Consultation Response from KC, Highways Development Management (HDM)
2023/93667 Storthes Hall Student Village, Storthes Hall Lane, Kirkburton, Huddersfield, HD8 0WA
Outline application for demolition of buildings and erection of residential development (up to 261 dwellings), redevelopment of Lodge Cottage for residential use and associated works.
Date Responded: 31/03/25
Responding Officer: A.Darwin
Responding Ref: K12-27/4

RECOMMENDATION: No objection, subject to conditions and S106 requirements

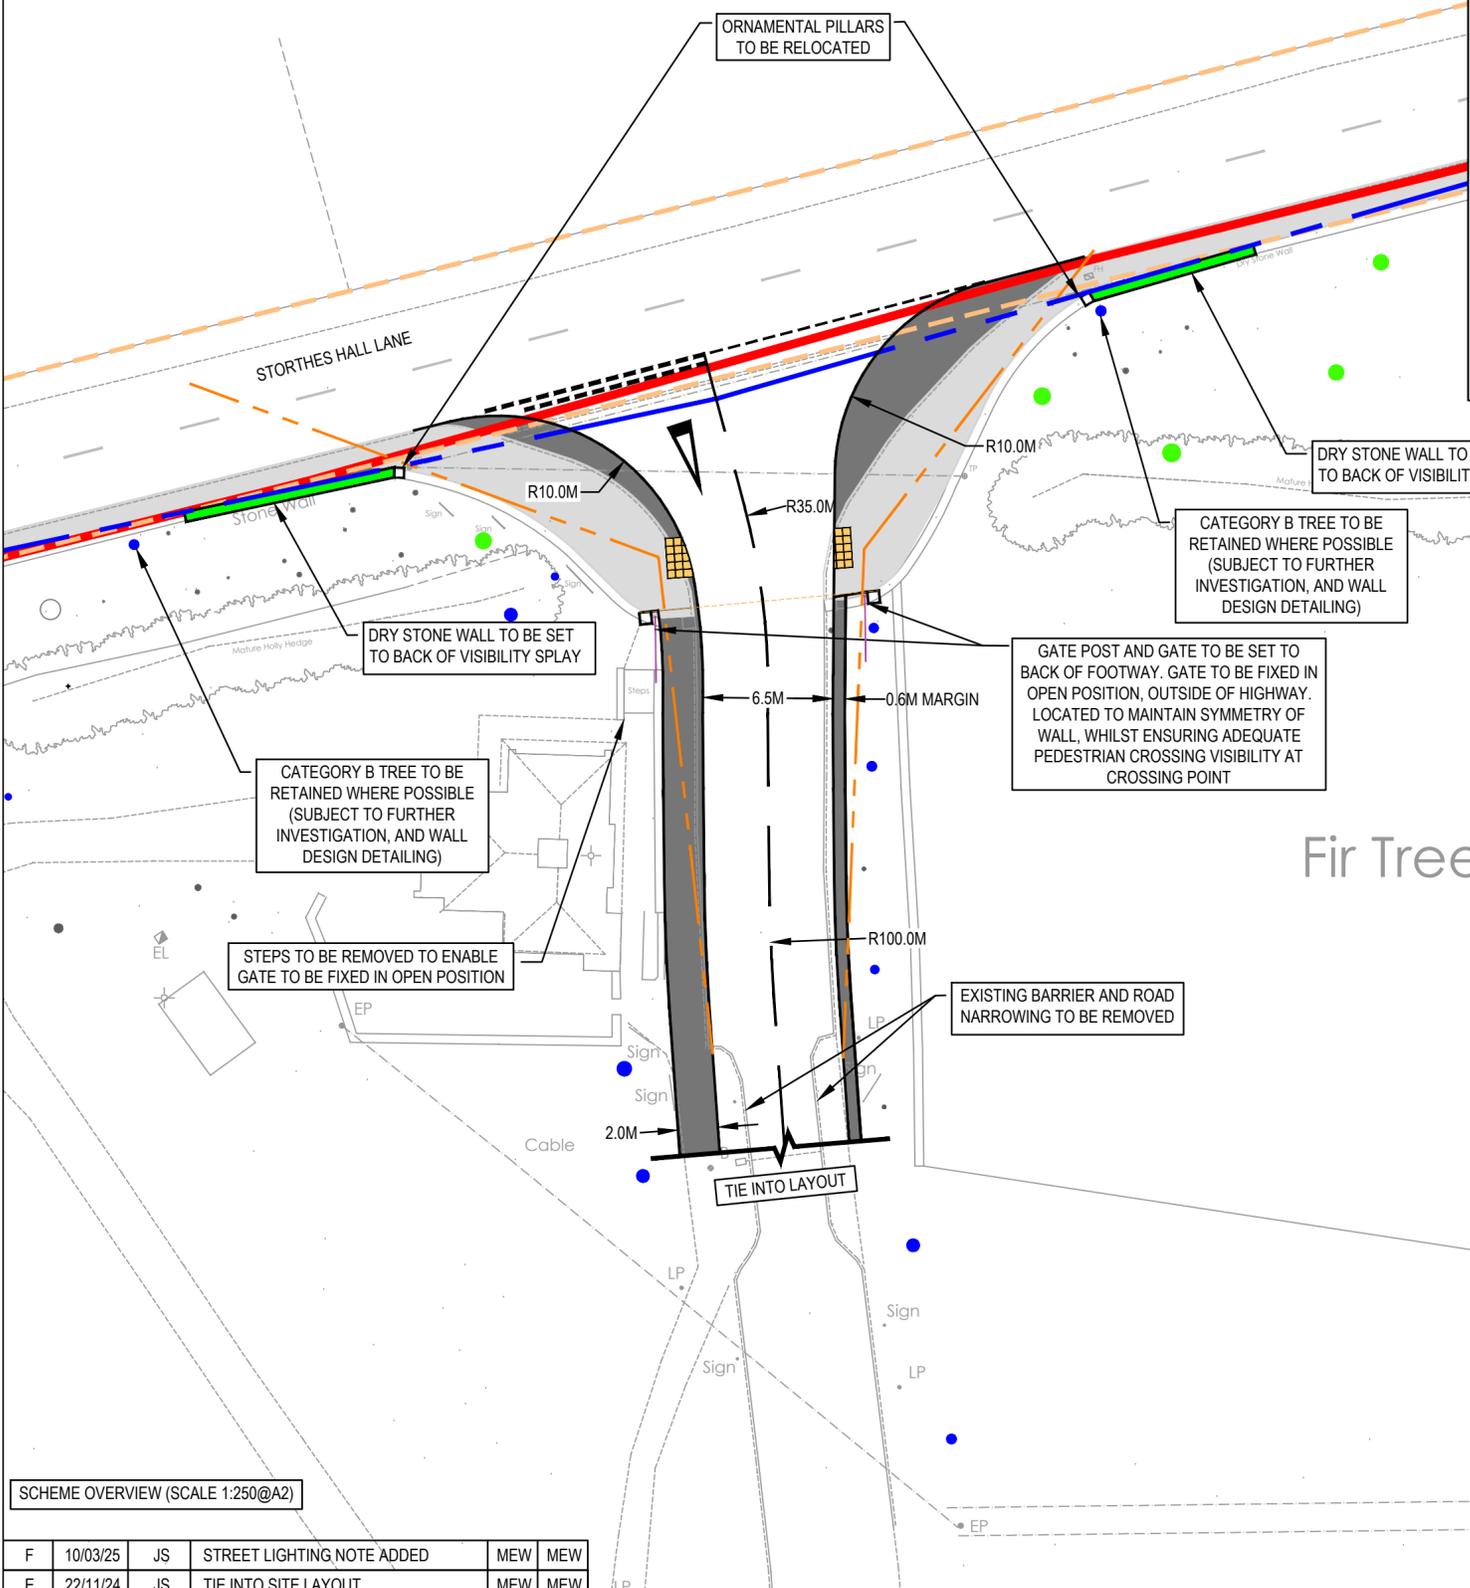
- The existing entrance is to be converted to a two-way vehicular access, and the existing security barriers are to be removed.
- Junction visibility is to be improved, to enable 2.4x90m visibility splays (measured to nearside wheeltrack) to be provided. These splays have been determined based on DMRB (based on 'one step below desirable minimum' SSD parameters) and MfS guidance, and are informed by the existing speed limit on Storthes Hall Lane and recorded vehicle speeds. These visibility splays will enable the access to operate safely on a two-way basis, but have been kept to minimum DMRB standards to minimise impact on the adjacent boundary walls and trees.

- The existing junction bellmouth is currently very wide. Therefore, to encourage lower turning speeds at the junction, the junction radii have been reduced to 10m. However, the reduced radii are still able to accommodate the turning movement of large vehicles (e.g. buses).

- The site access is proposed to include an improved footway link on the south side. Typically adoptable estate roads require footways on both sides. However, a single footway is proposed in this instance, to minimise impact on trees and the listed gate-posts, with a 0.6m margin provided instead of a second footway. This is acceptable in this instance, given that the initial section of site access road will not directly serve any dwellings.

- The site access carriageway is to be widened to 6.5m for the initial section (widening to 6.75m further into the site) to accommodate two-way use by buses and other large vehicles.

- To accommodate the site access alterations, it is necessary to amend the existing boundary walls, listed gates (and gate posts), and steps at the existing security lodge. This includes relocating the existing gates to the back of the proposed highway, which would then be fixed in an open position. These indicative proposals have been developed to minimise impact on these heritage assets and maintain their character; and the changes are understood to be acceptable in principle to the Councils Conservation and Design Team.

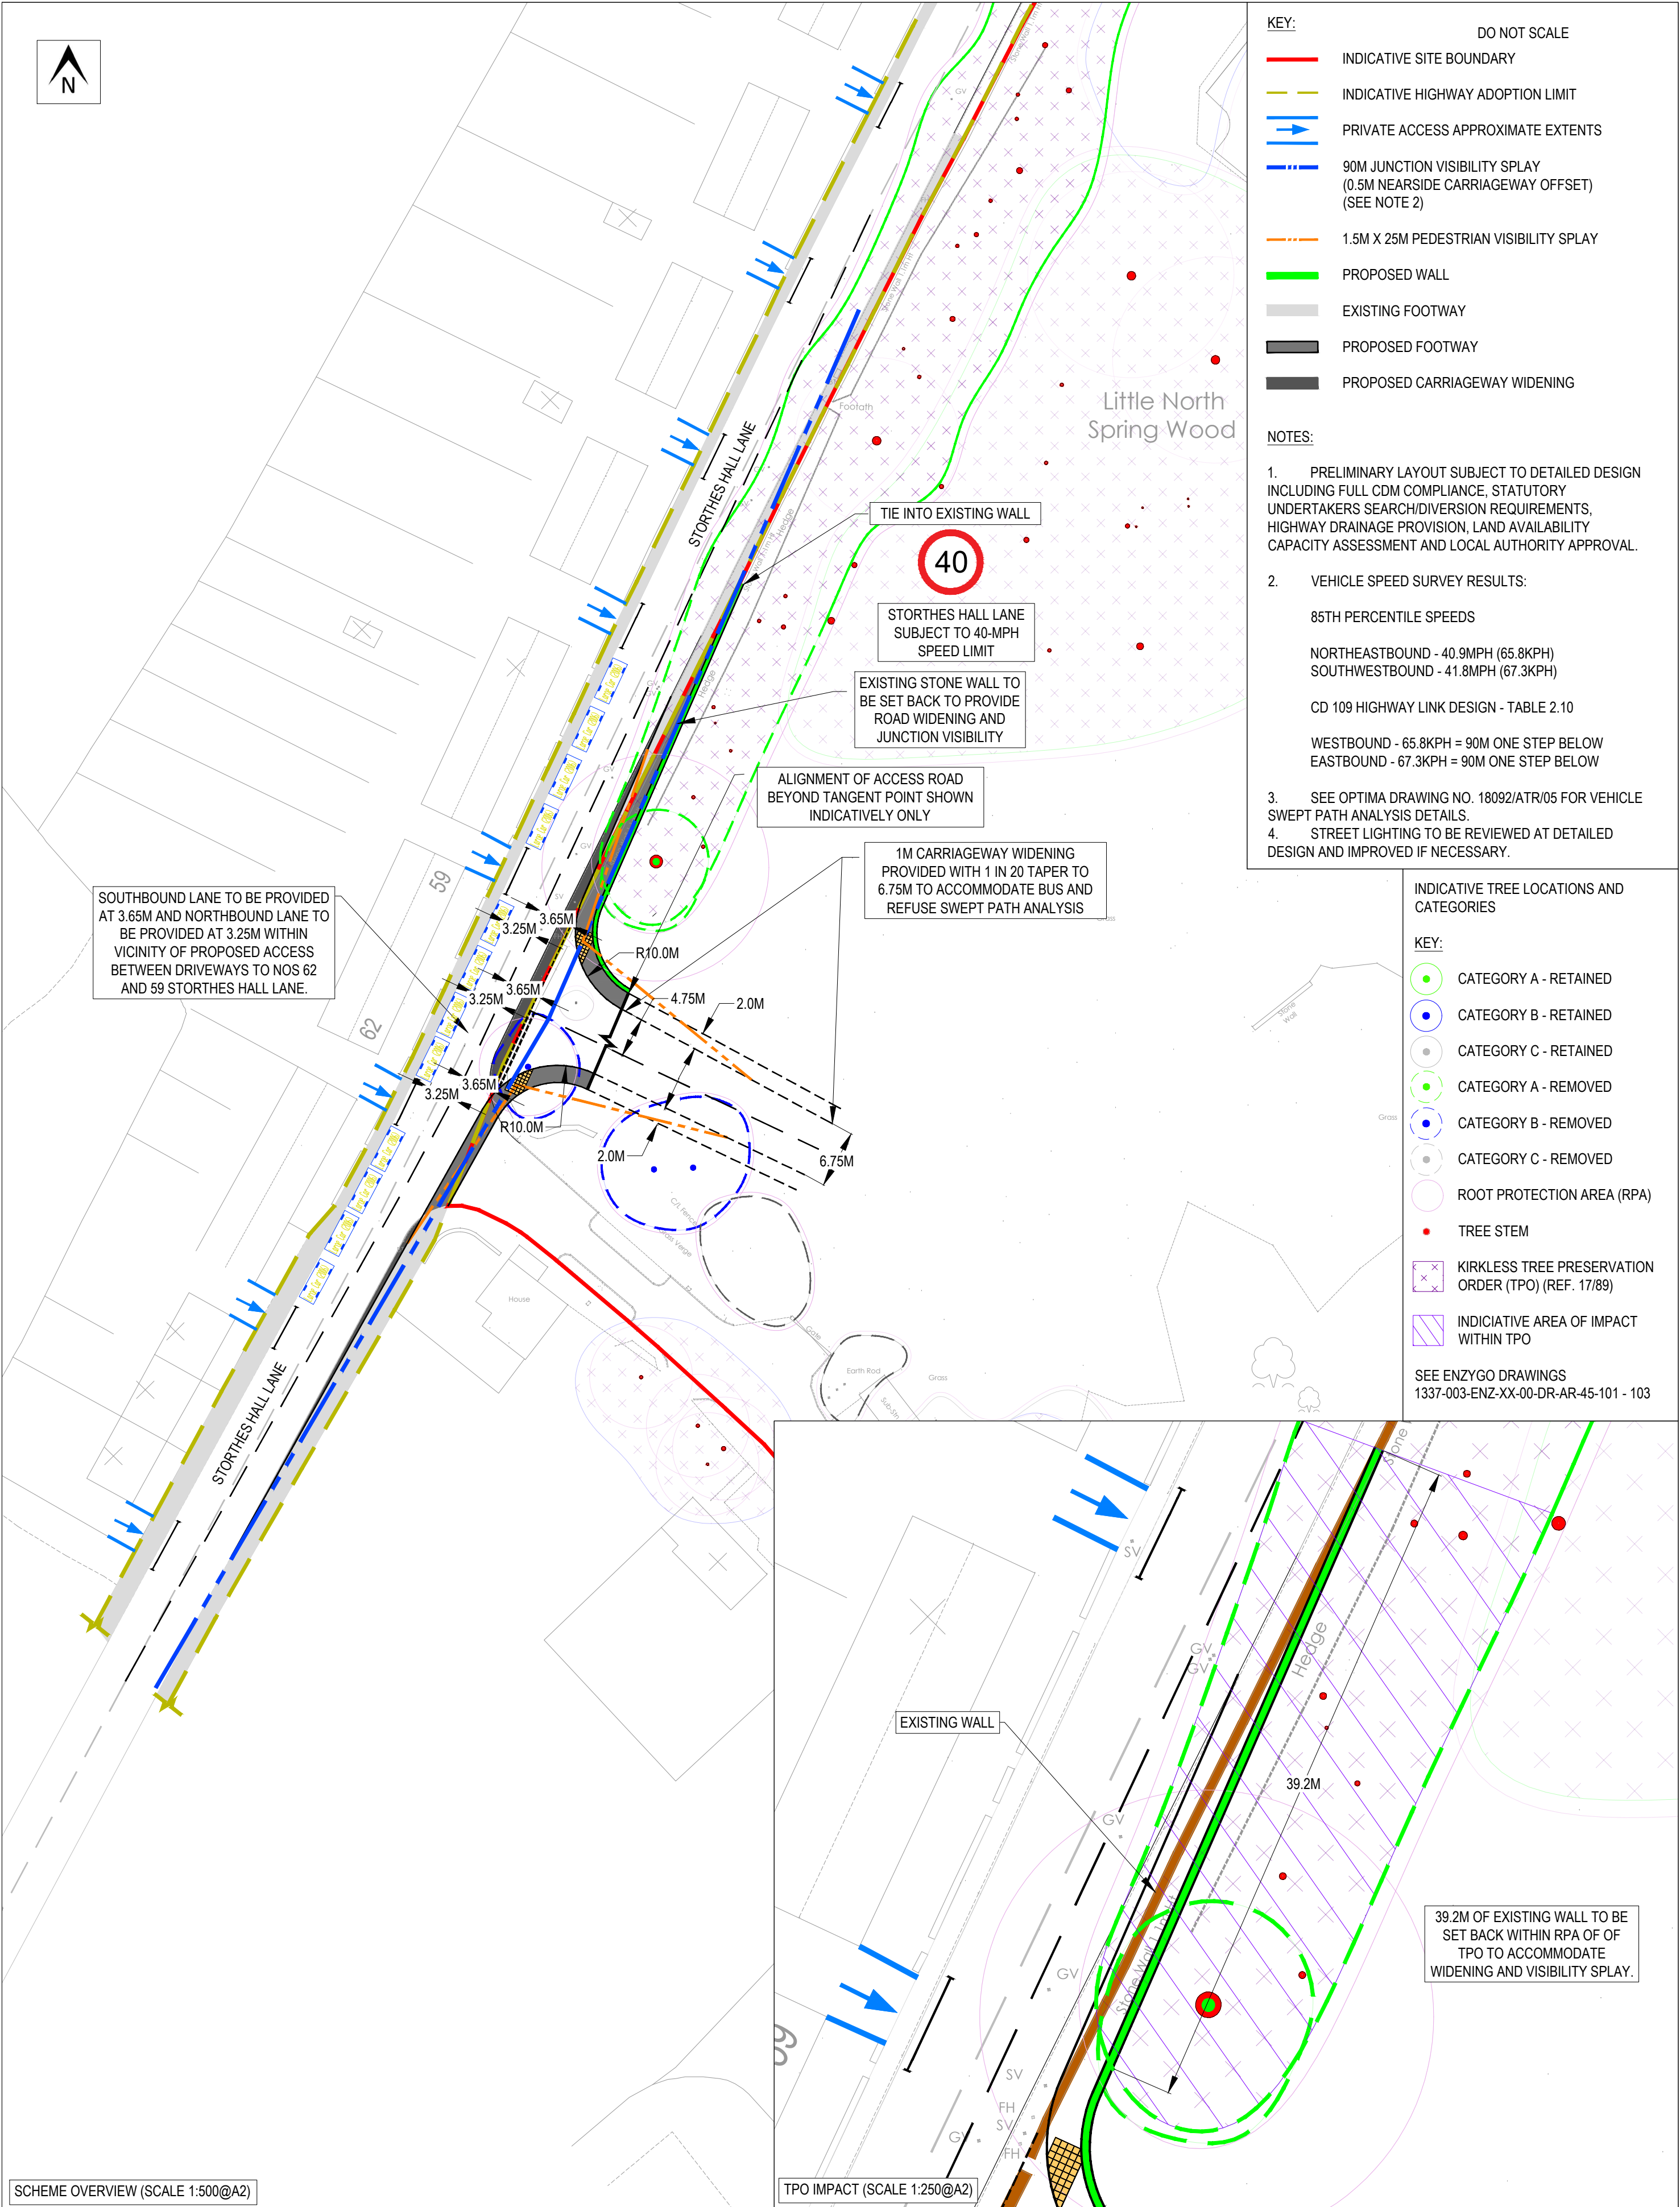
- The existing exit is to be converted to a two-way vehicular access, and the existing security barriers are to be removed.
- Following recommendations made in the Stage 1 Road Safety Audit, Storthes Hall Lane is proposed to be locally widened (by circa 1-1.5m) within the vicinity of the access. This is to enable traffic to turn and pass within the vicinity of the junction, even when on-street park takes place opposite the junction (that frequency occurs, particularly outside of daytime periods). To enable the carriageway widening, it has been necessary for the access to be relocated circa 15m to the north. The access relocation has been kept to a minimum, but still results in some impact on a number of mature trees. Therefore, careful design will be required at the detailed design stage, to minimise the impact on trees and the associated tree loss.

- Junction visibility is to be improved, to enable 2.4x90m visibility splays (measured to nearside wheeltrack) to be provided. These splays have been determined based on DMRB (based on 'one step below desirable minimum' SSD parameters) and MfS guidance, and informed by the existing speed limit on Storthes Hall Lane and recorded vehicle speeds. These visibility splays will enable the access to

- The relocated junction has been designed with 10m radii (and tapers on the minor arm) to accommodate the turning movement of large vehicles (e.g. buses), and takes into account the presence of on-street parking opposite the junction on Storthes Hall Lane.
- The site access road is designed to accommodate a 6.75m wide spine road (designed to residential collector road standard, and to accommodate a future bus route), with 2m wide footways on both sides.

INDICATIVE MASTERPLAN - STORTHES HALL, KIRKBURTON

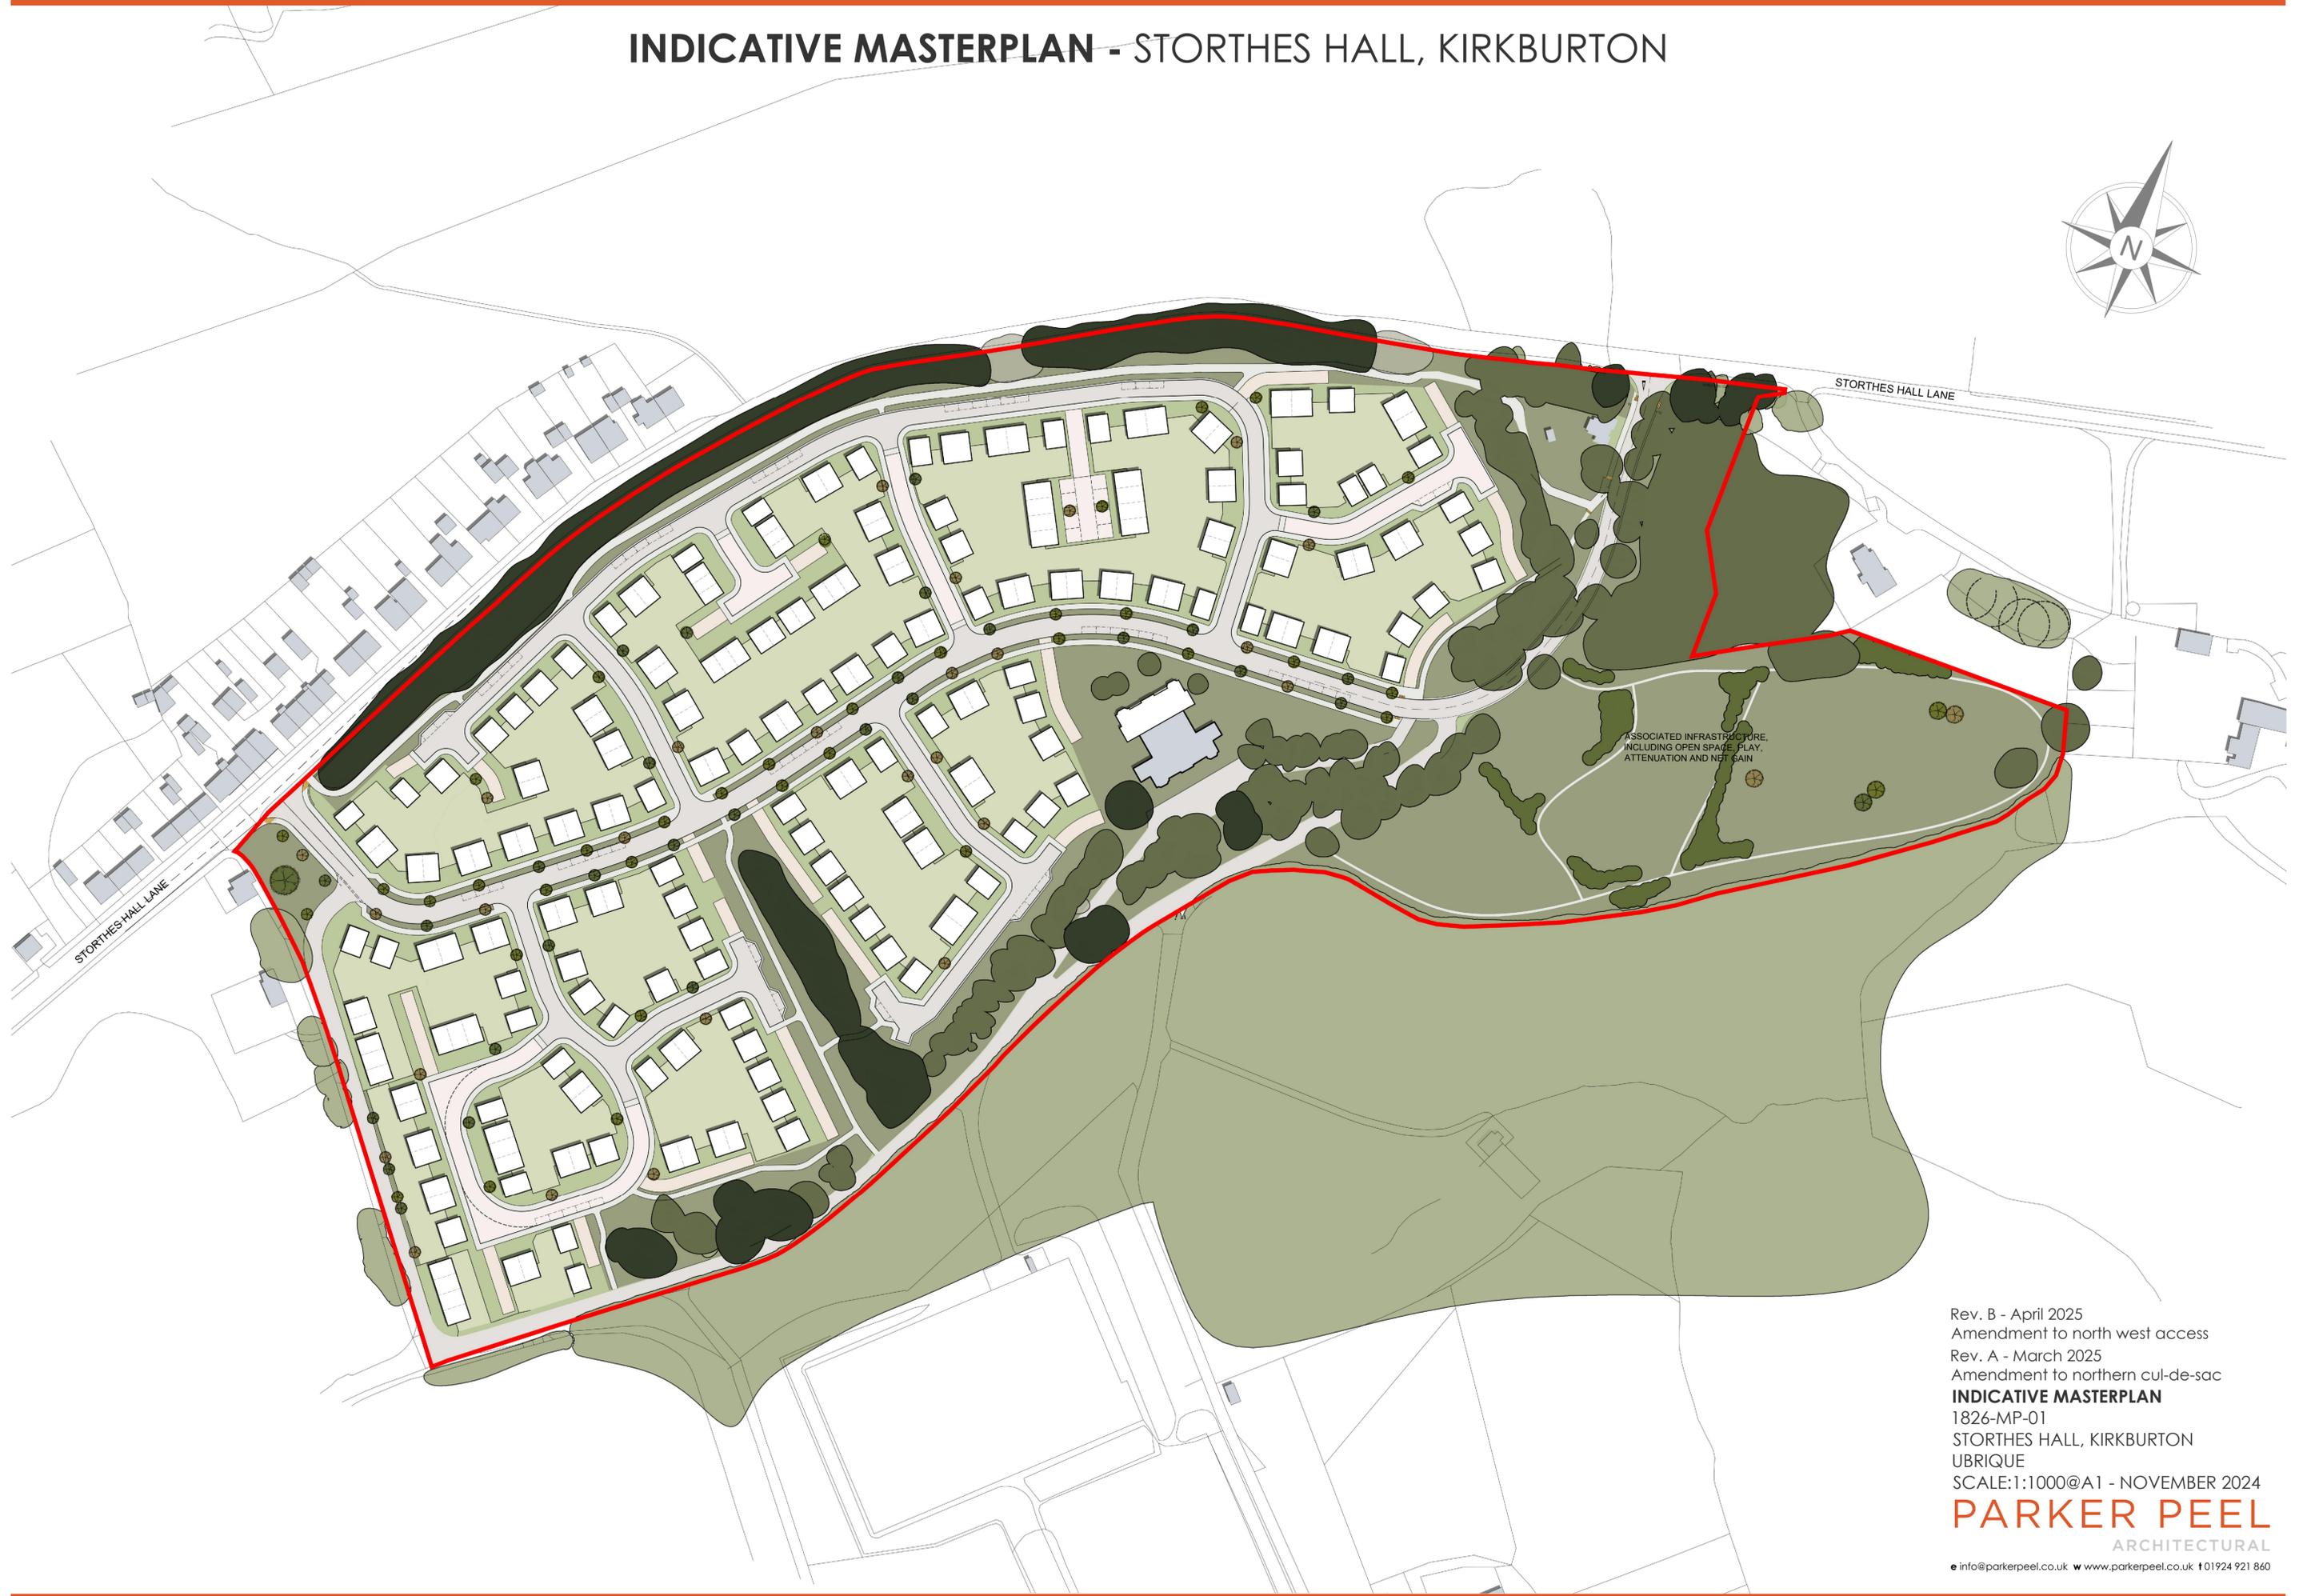
the woods to the south) and to the adjacent development site. A pedestrian/cycle link should also be provided within the site, running parallel to Storthes Hall Lane, as currently indicated on the Illustrative Masterplan. Further details of active travel links and connections into and within the site should be secured by condition.
